**Supplementary Detailed Submission
New High School in Bungendore (SSD-14394209)
Objection to Proposal**

Submission and Comments from Council on Bungendore High School - SSD-14394209

Council's Ref: PR.2021.1036
DPIE Ref: SSD-14394209
Council Contact: M J Thompson
Council@qprc.nsw.gov.au

14 Revised Waste Vehicle Turning Strategy

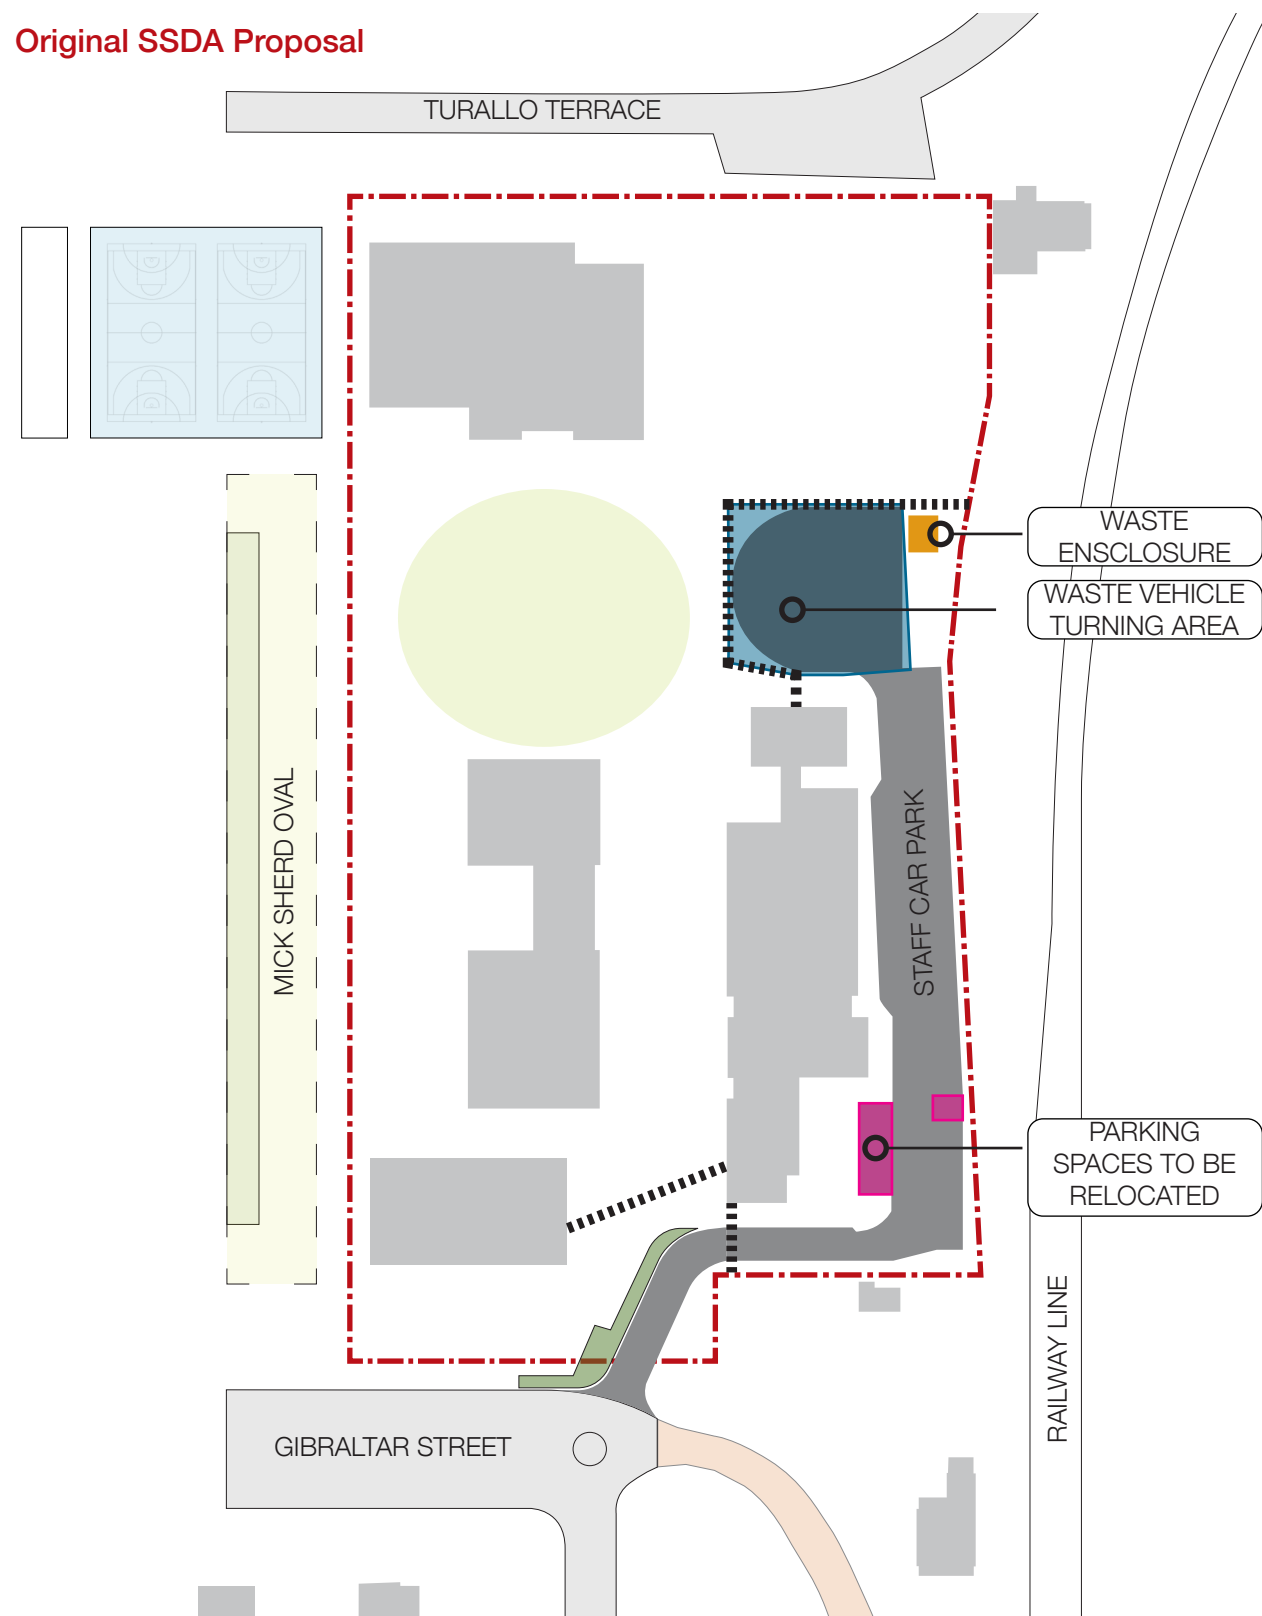
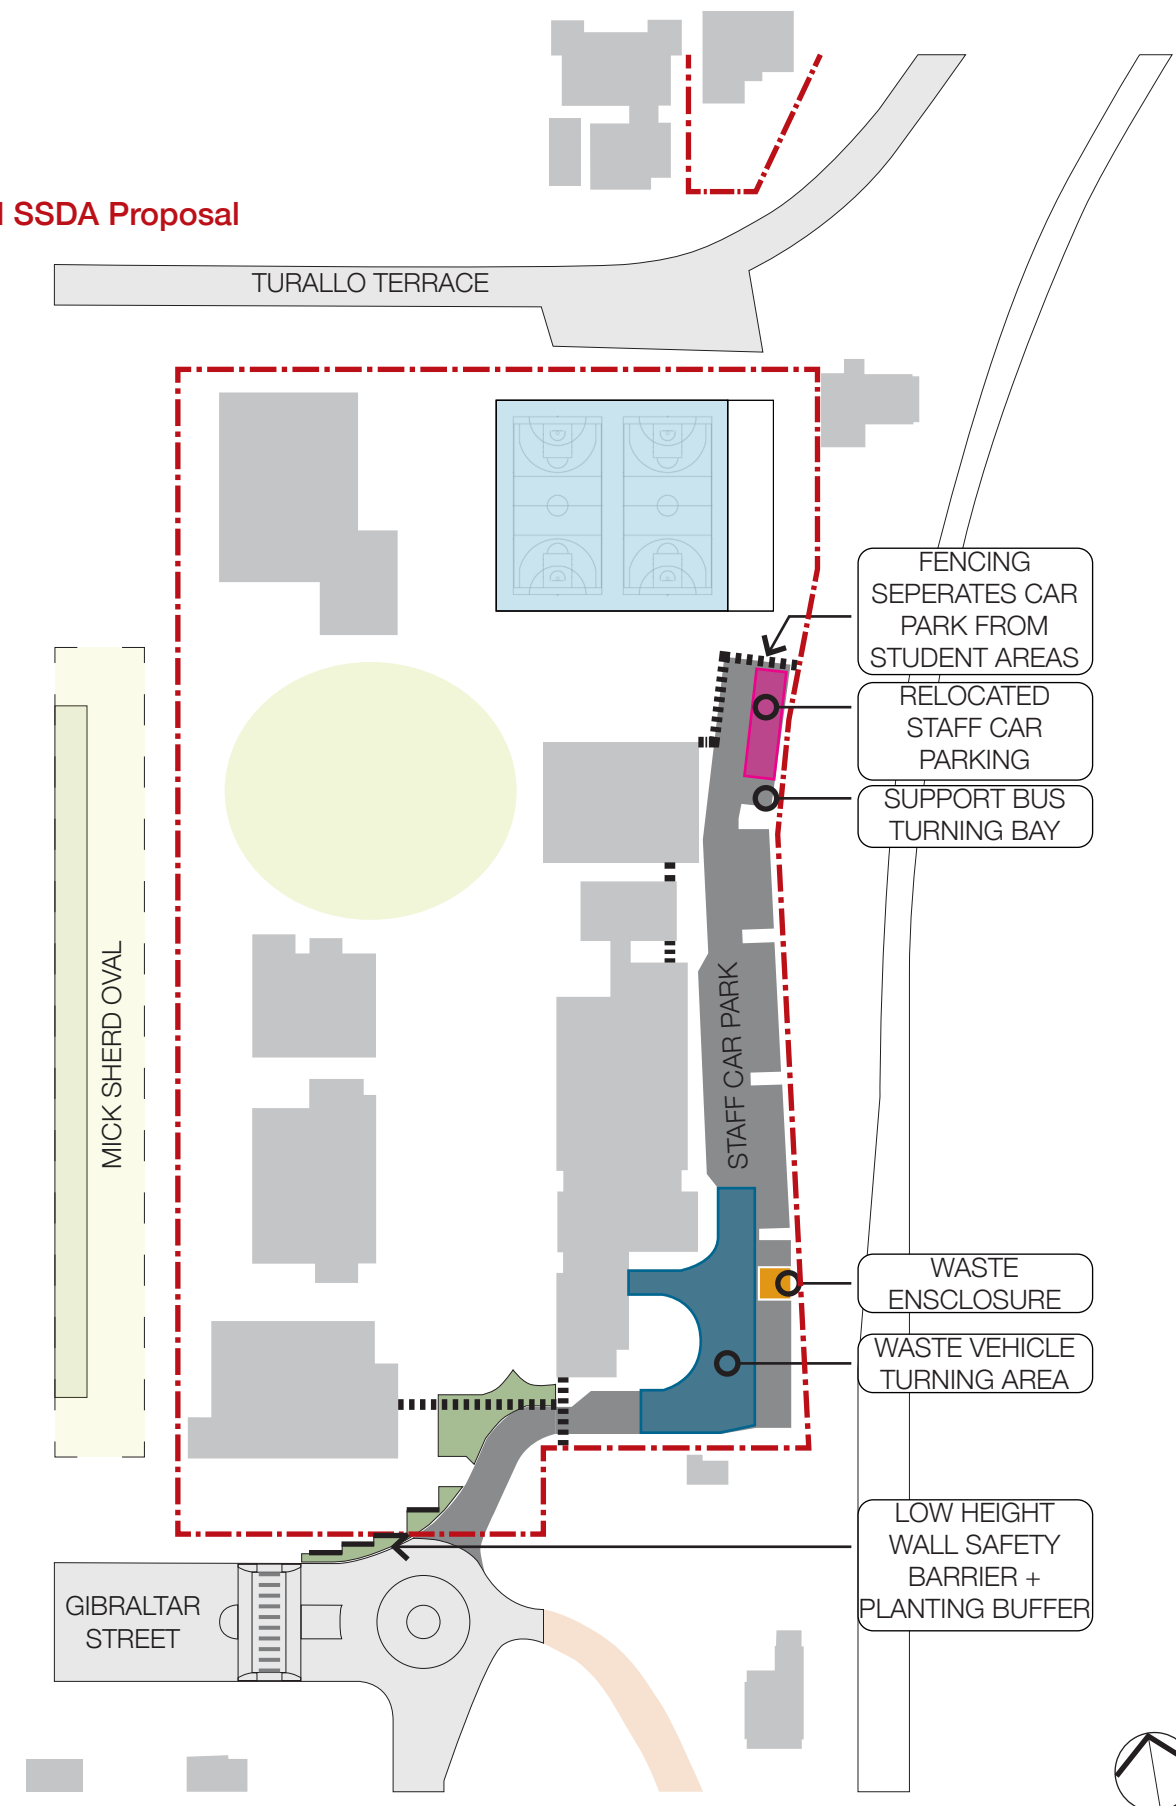
A new turning head is proposed to the northern end of the car park to facilitate turning of a waste collection vehicle.

17 Additional Community Parking

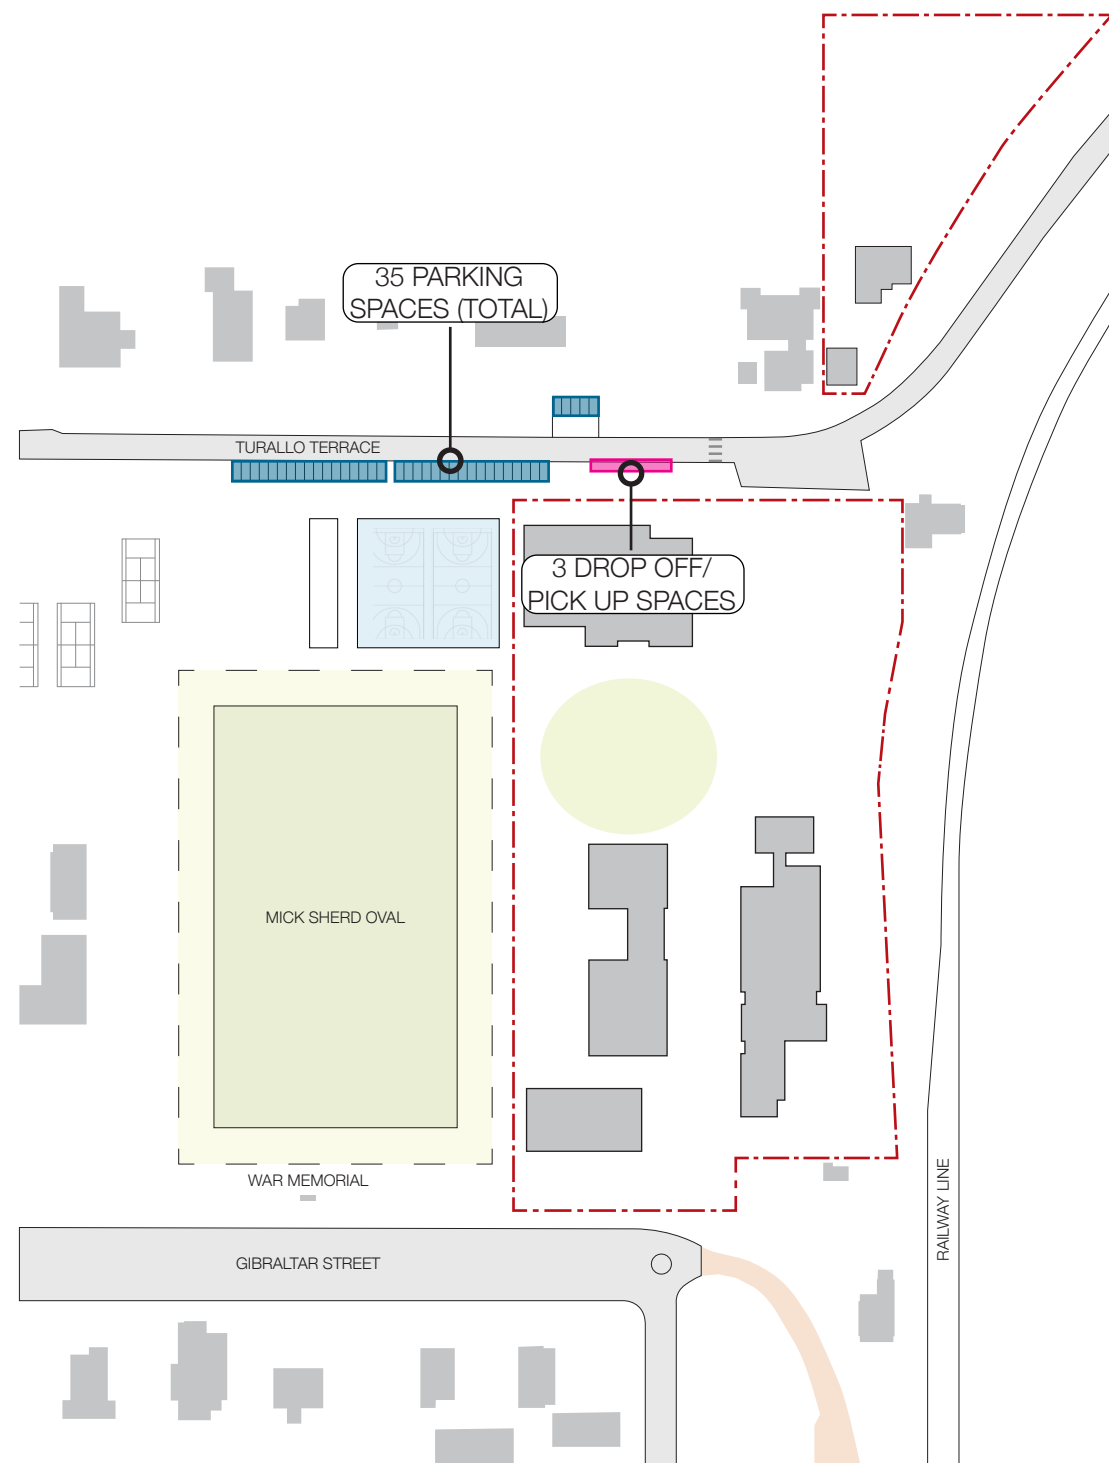
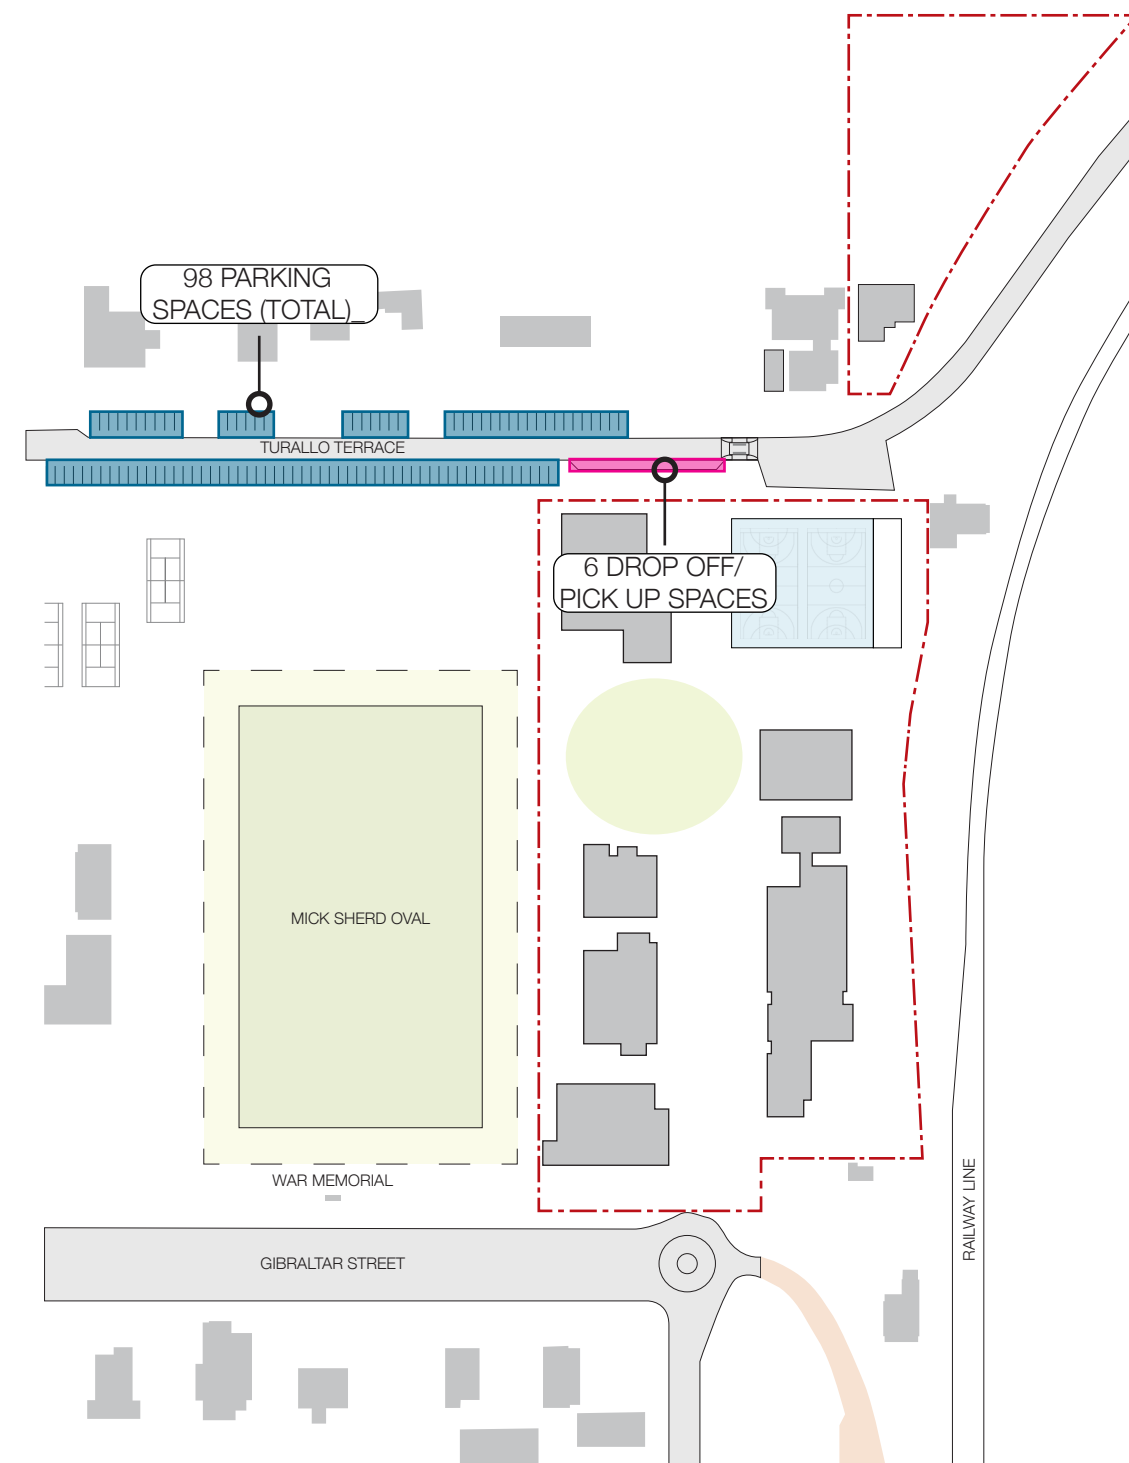
Of concern is the statement that 60 existing on street parking spaces are being lost i.e. there is a net loss of 20 carparking spaces. This is not considered acceptable given the additional demands the School will impose on the surrounding neighbourhood.

It would appear therefore that the School project is deficient in carparking o the tune of $20 + 15 + 23 = 58$ carparking spaces.

It would therefore seem appropriate that the School project be required to provide, at a minimum, an additional 58 on street spaces to compensate for the loss of parking in Majara Street and for new demand created. This could be by an extension of the proposed indented 90 degree bays off Turallo Terrace on both the northern and southern sides of the road. In addition, the construction of indented parallel parking in Butmaroo Street could be considered as an option. Separate discussions by the applicant should be held with adjacent landowners.
